REFUSAL OF PLANNING PERMISSION

APPLICATION NO. 2019/0796

Proposal Erection of dormer window extension on front roof plane (Retrospective)

At 16 Strafford Walk, Dodworth, Barnsley, S75 3RB

DRAWING
Proposed Plans & Elevations

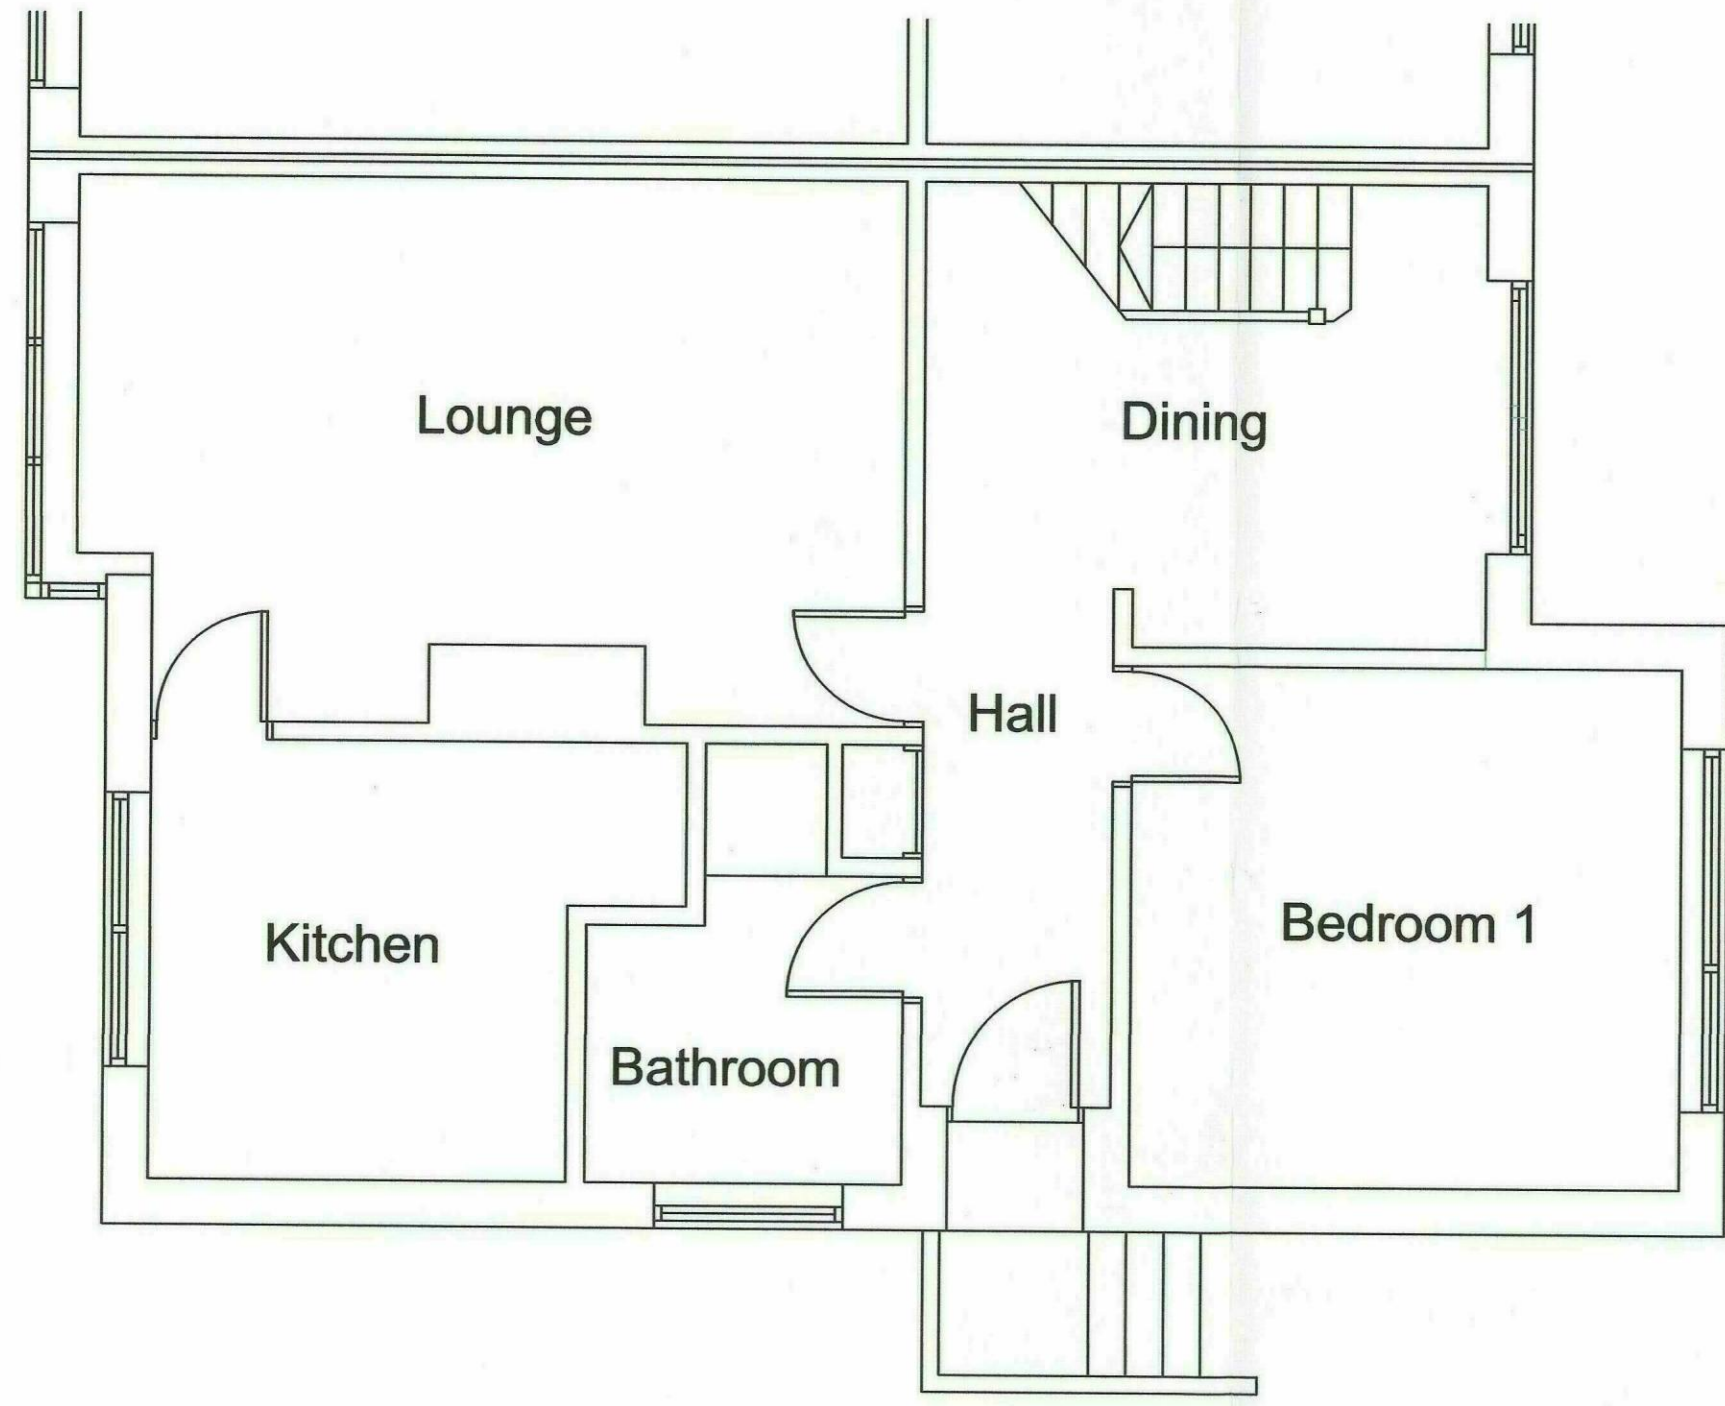
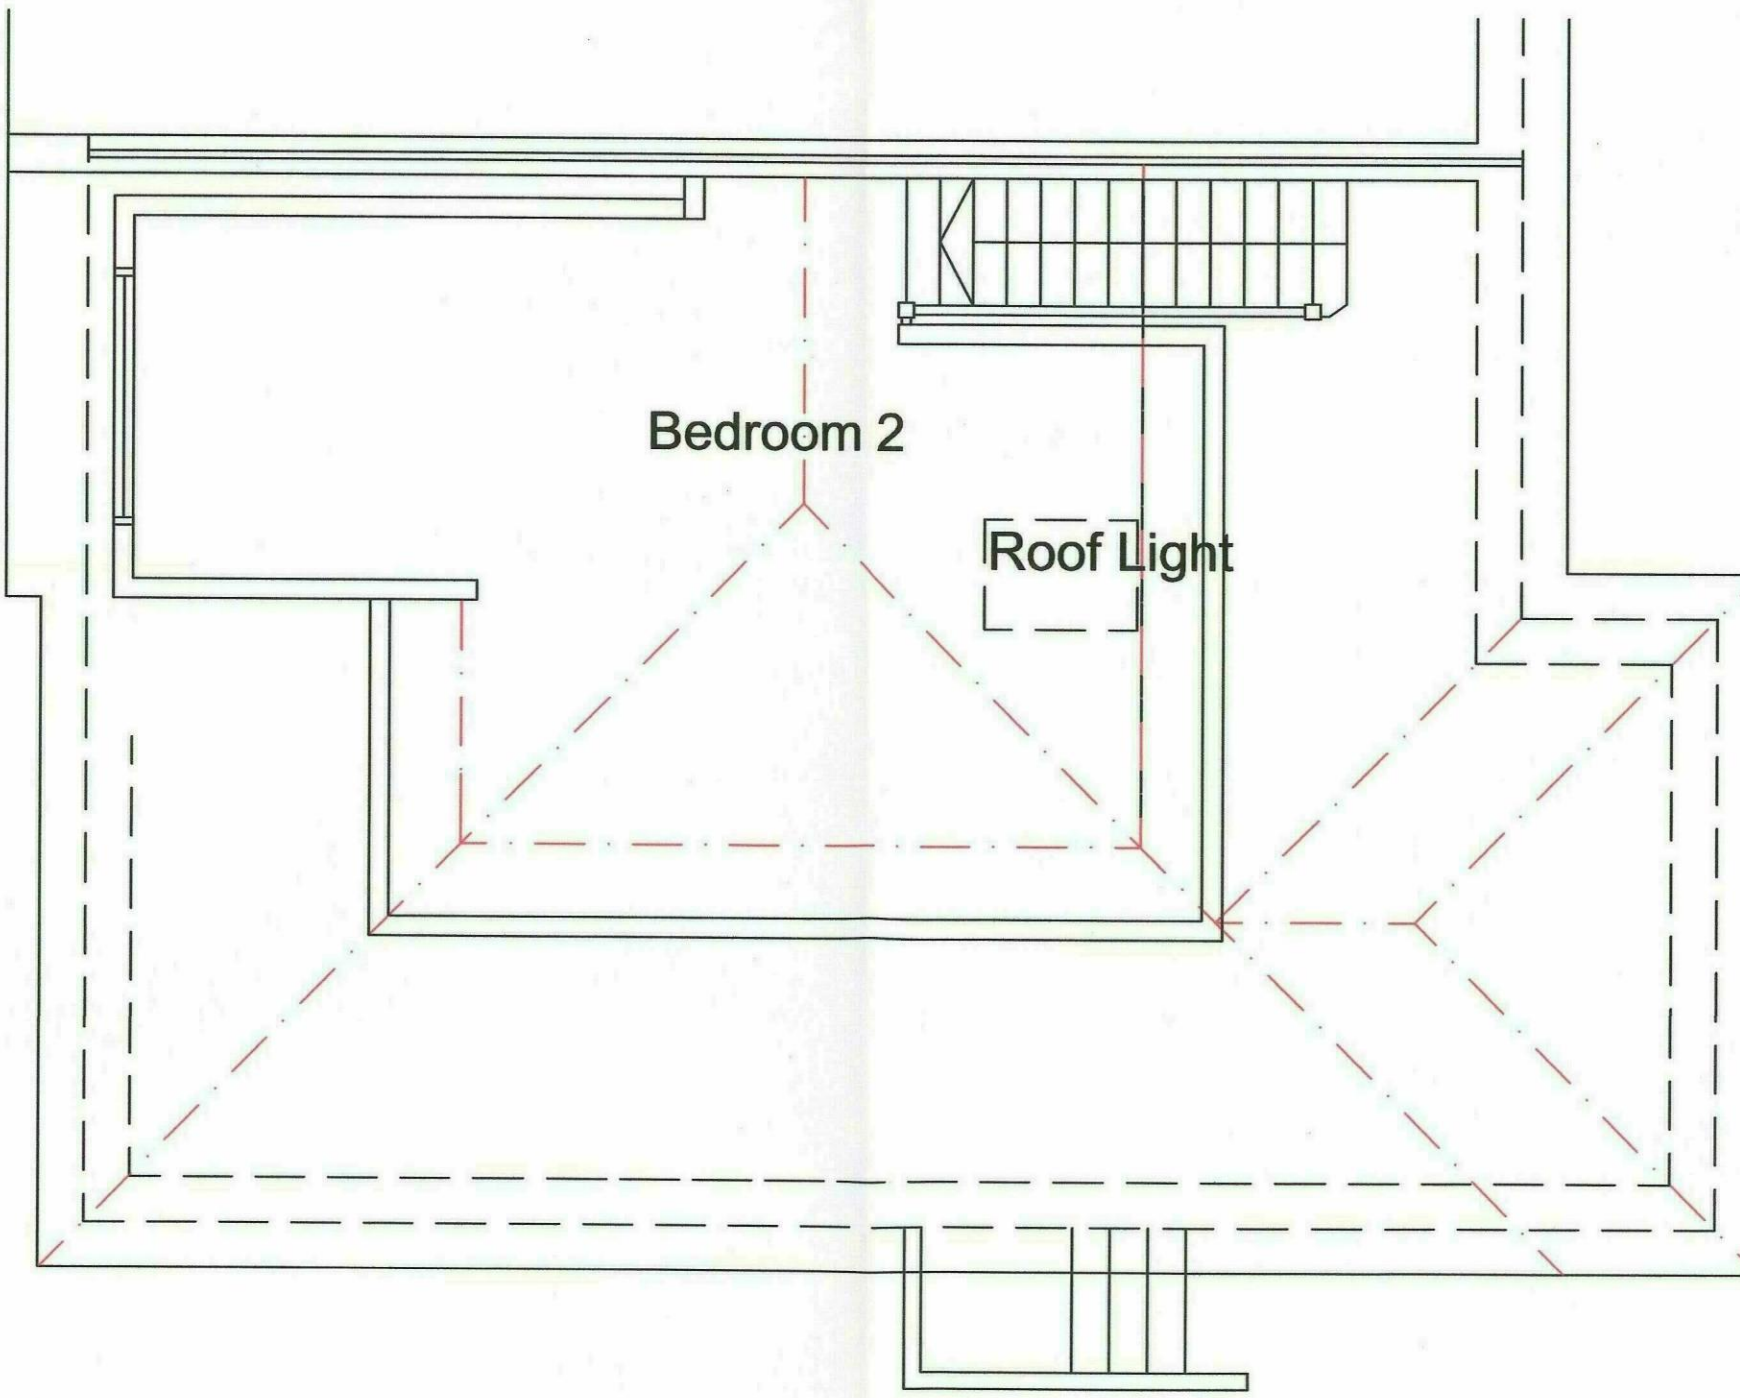
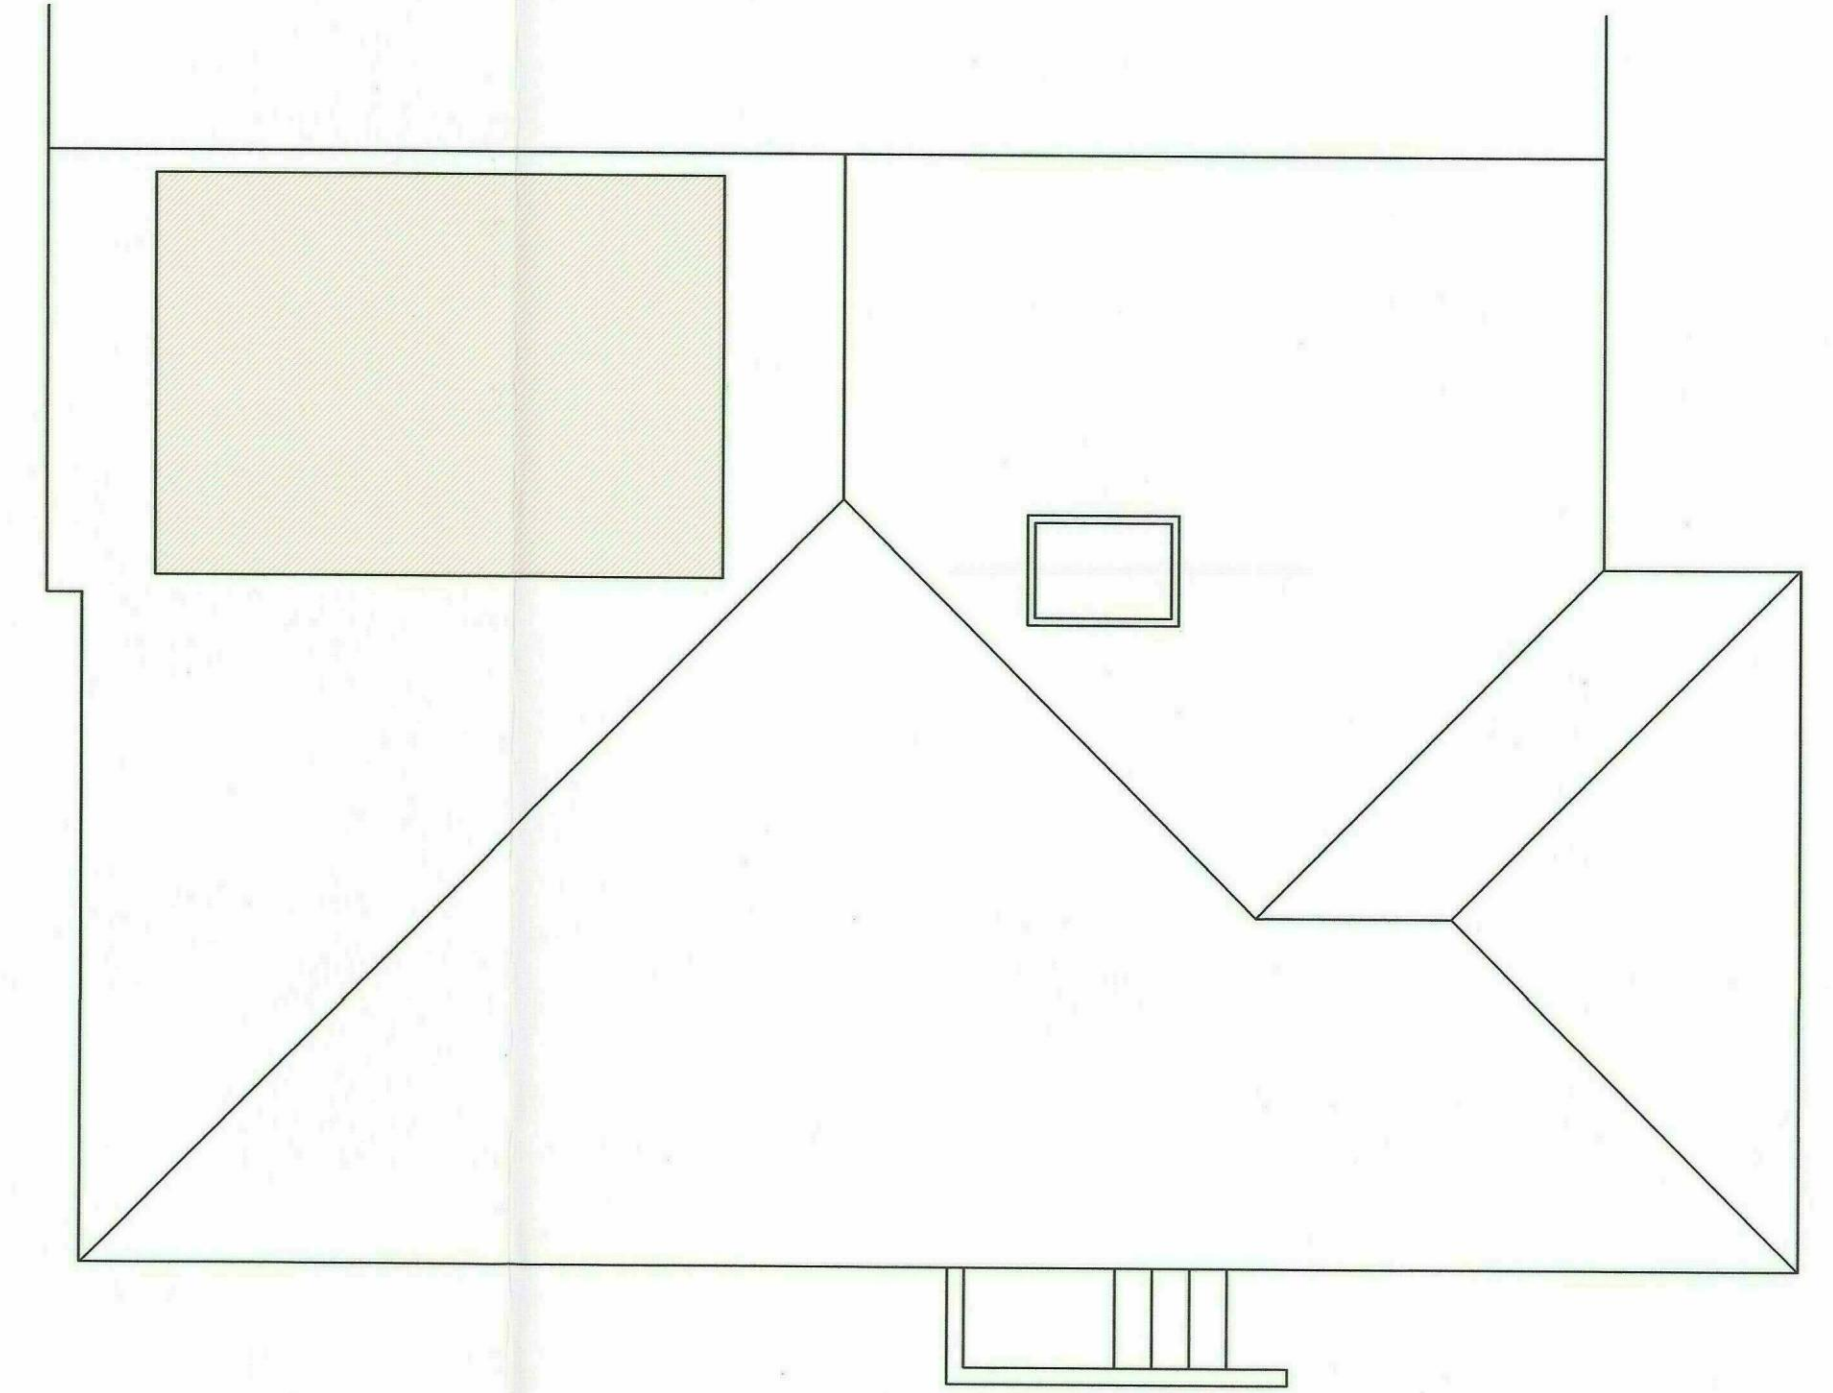
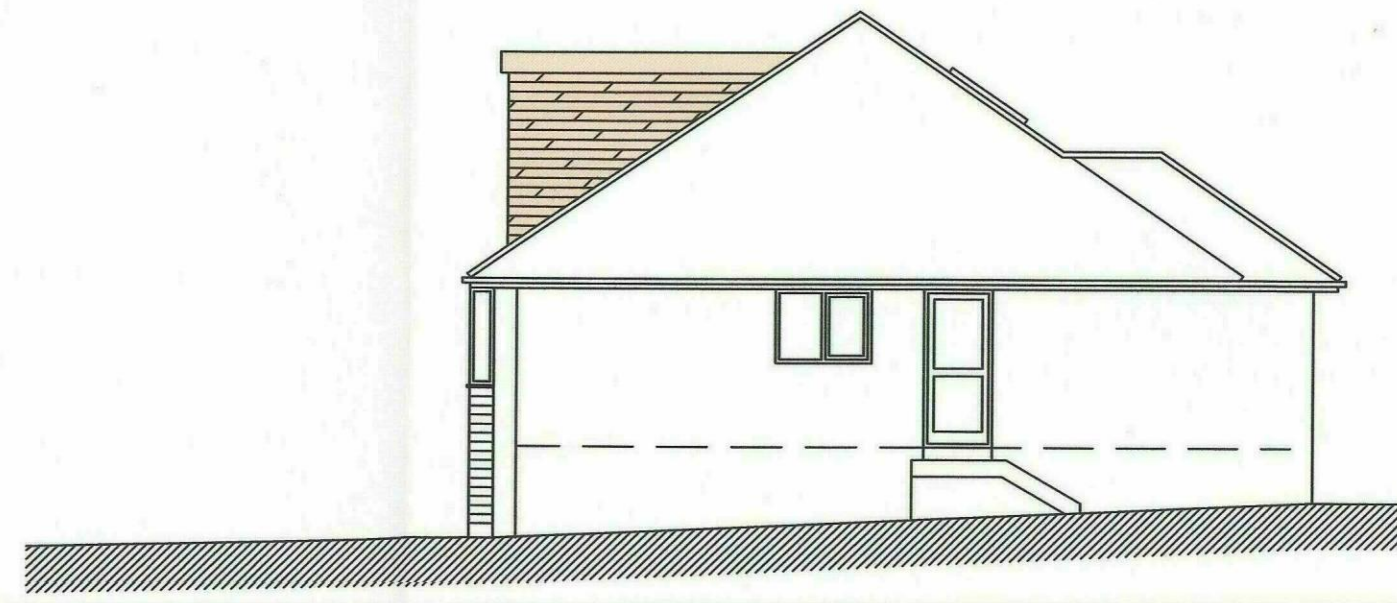
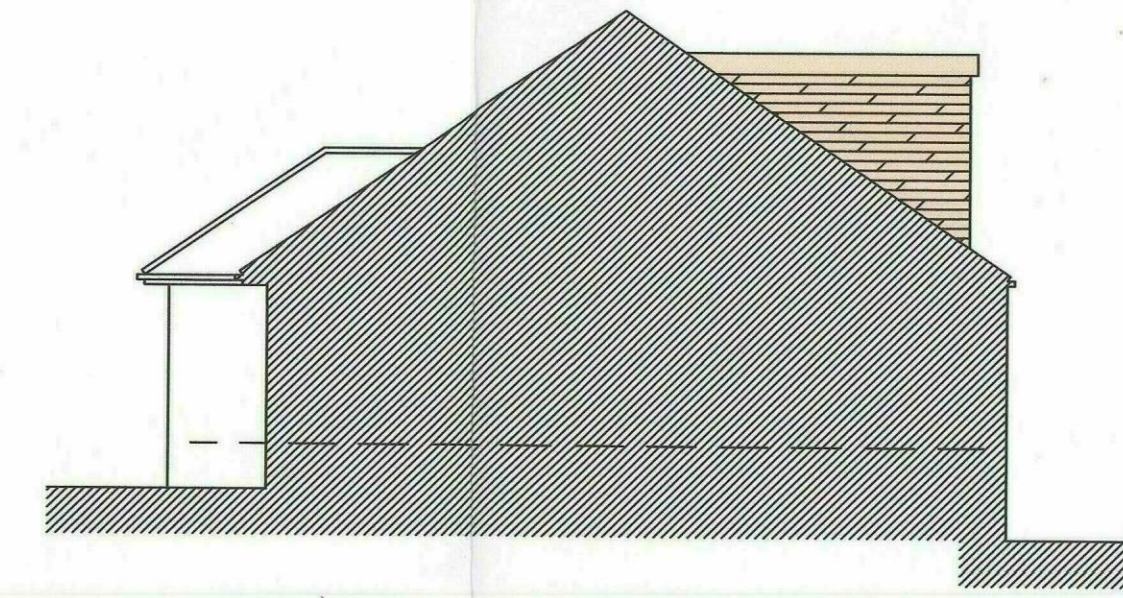
| 1 | In the opinion of the Local Planning Authority the proposed dormer extension on the front elevation of the property is considered to be inappropriate and incompatible to its context, being of excessive scale and a design which does not harmonise with the existing bungalow adversely impacting on its appearance. Furthermore, its material construction detracts from the appearance of the property and, as a consequence, appears as an unduly intrusive feature in the street scene to the detriment of visual amenity. As such, the proposal is contrary to Local Plan Policy D1- High Quality Design and Place Making and the Council's Supplementary Planning Document - House Extensions. |
